**Project Name**  
 Birdworld & Haskins Forest Lodge  
 Farnham Road, Holt Pound,  
 Farnham GU10 4LD

## **APPENDIX B.** HCC Pre-Application Meeting Minutes

## **APPENDIX C. HCC Pre-Application Responses**

Thank you for your pre-application enquiry into the proposed expansion of Birdworld and Forest Lodge garden centre located to the north of Bucks Horn Oak.

The Square, Basing View,  
Basingstoke, Hampshire, RG21 4EB  
www.i-transport.co.uk

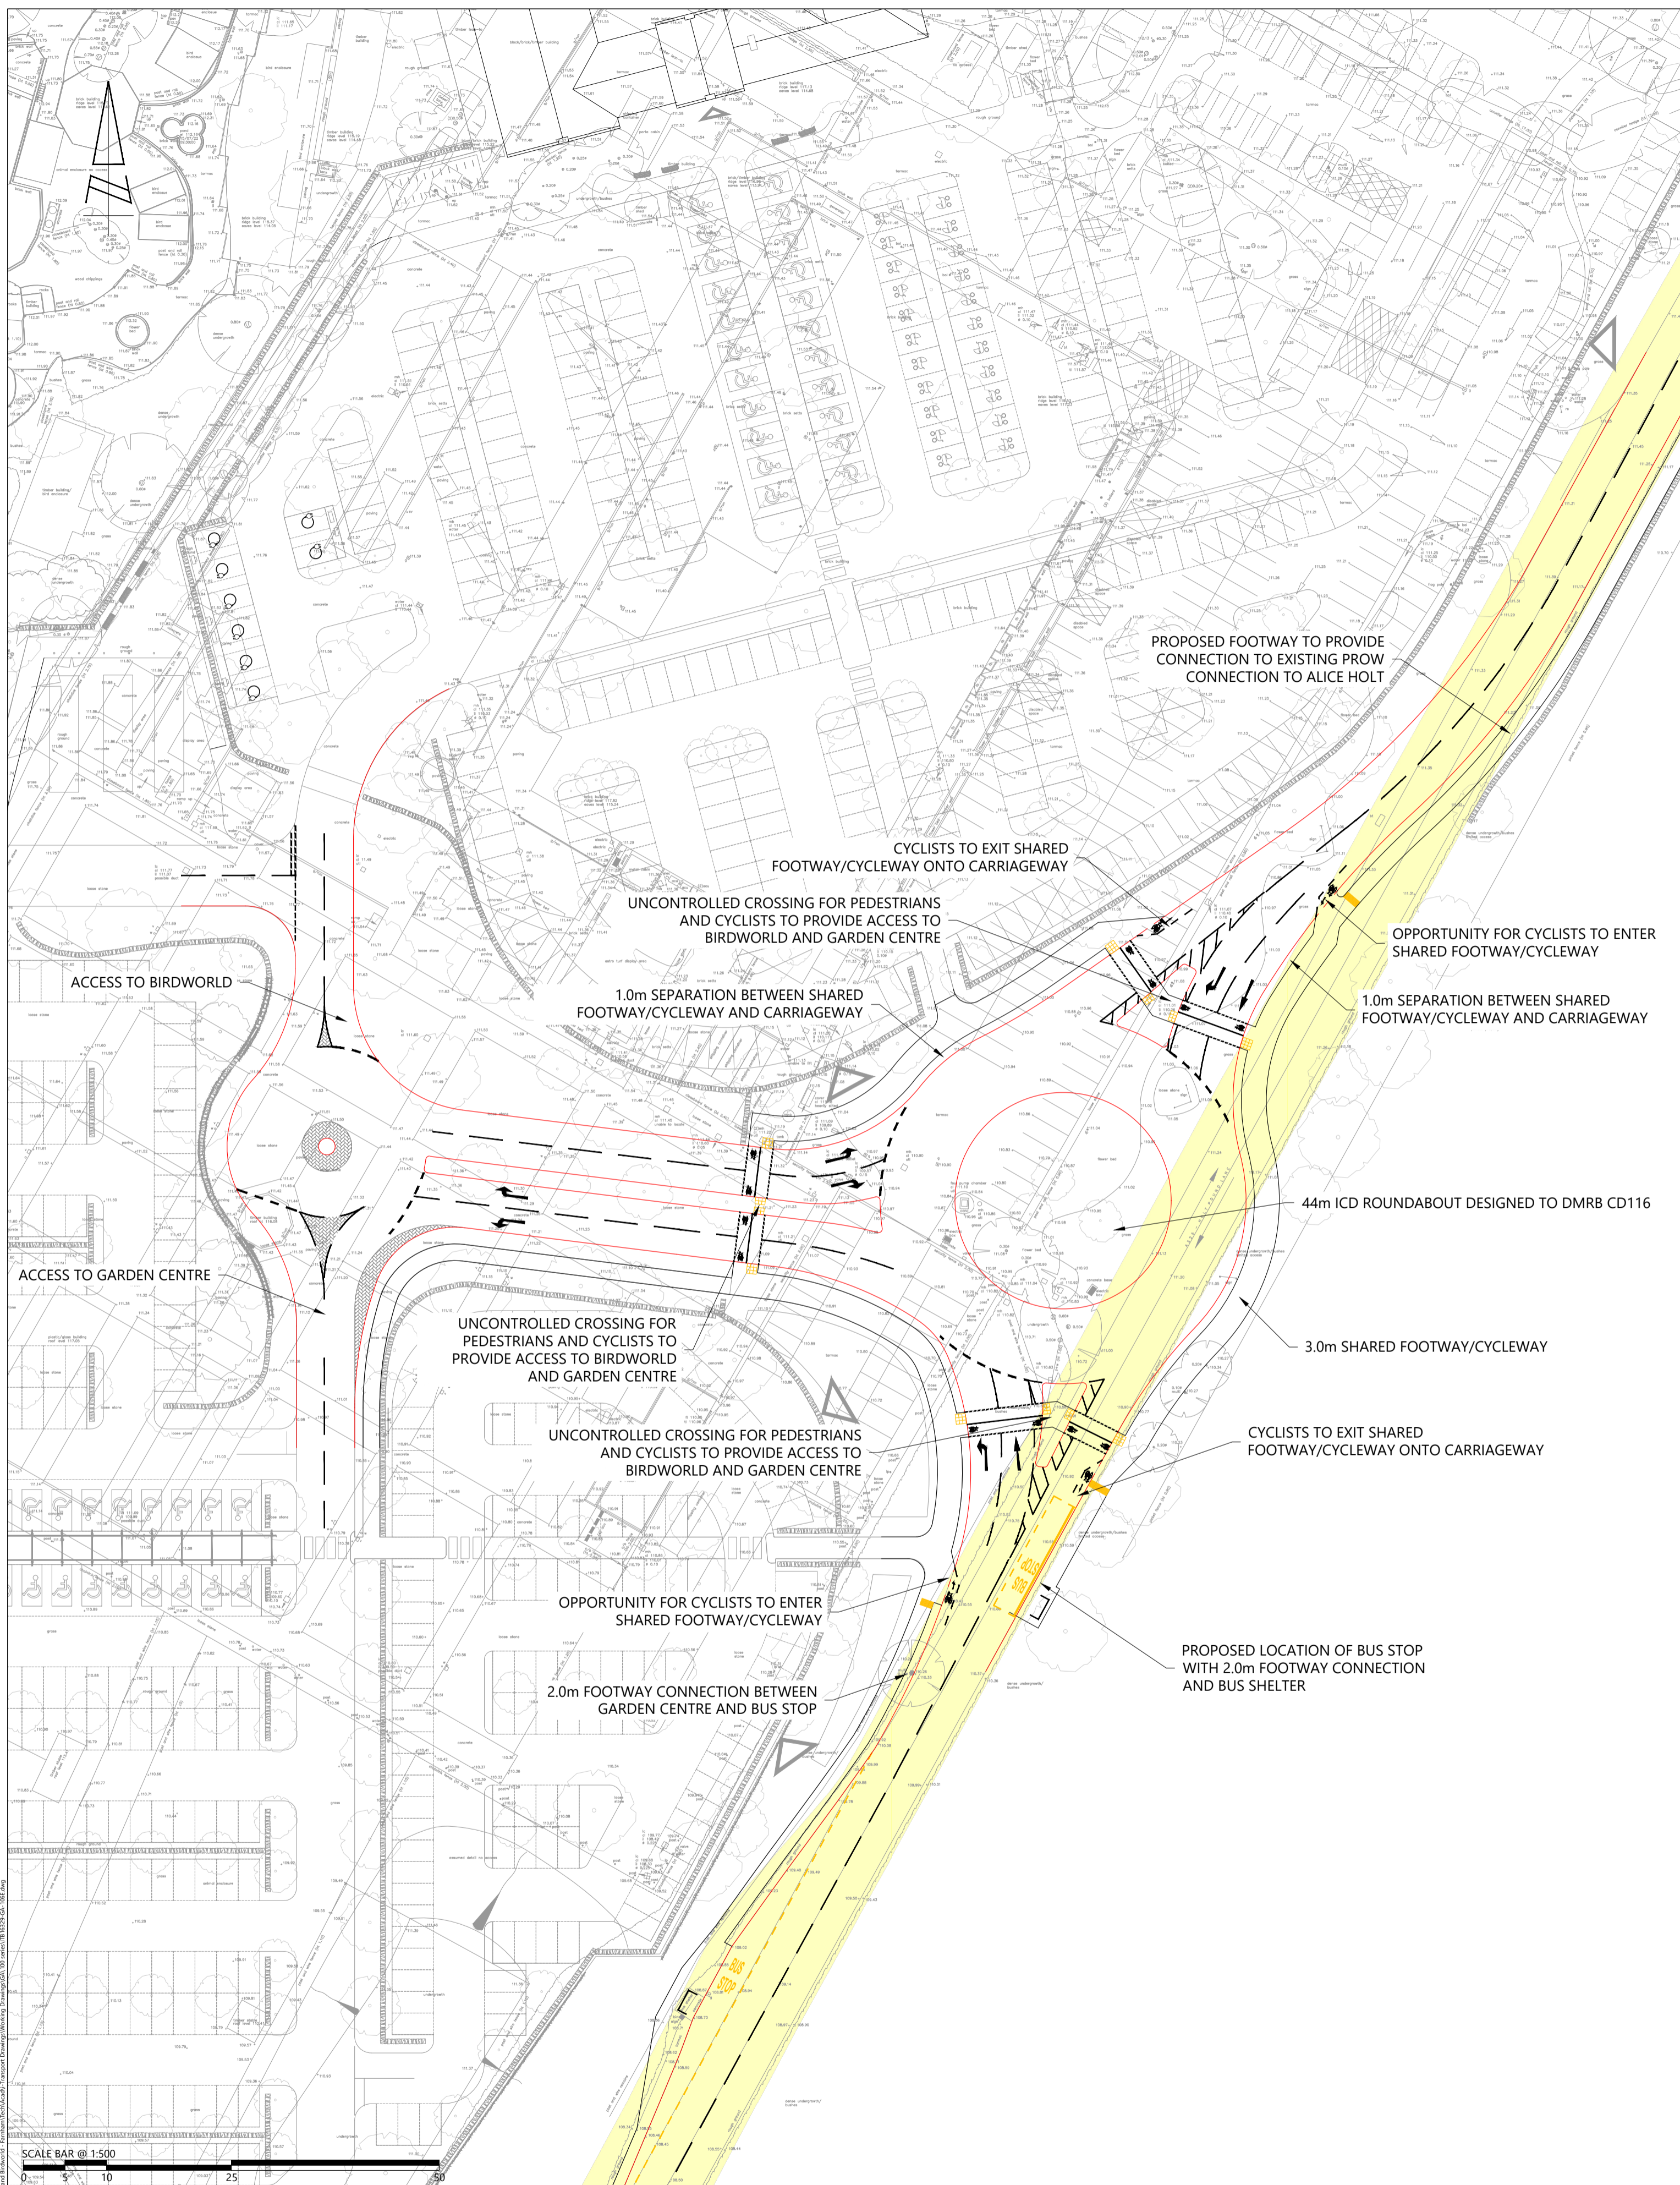
The southbound bus stop currently consists of a flag pole and timetable only. The applicant should investigate whether it is possible to provide a bus shelter in this location which would help to encourage the uptake of bus provision by providing dedicated waiting facilities. This would be especially beneficial given the current infrequency of the bus service.
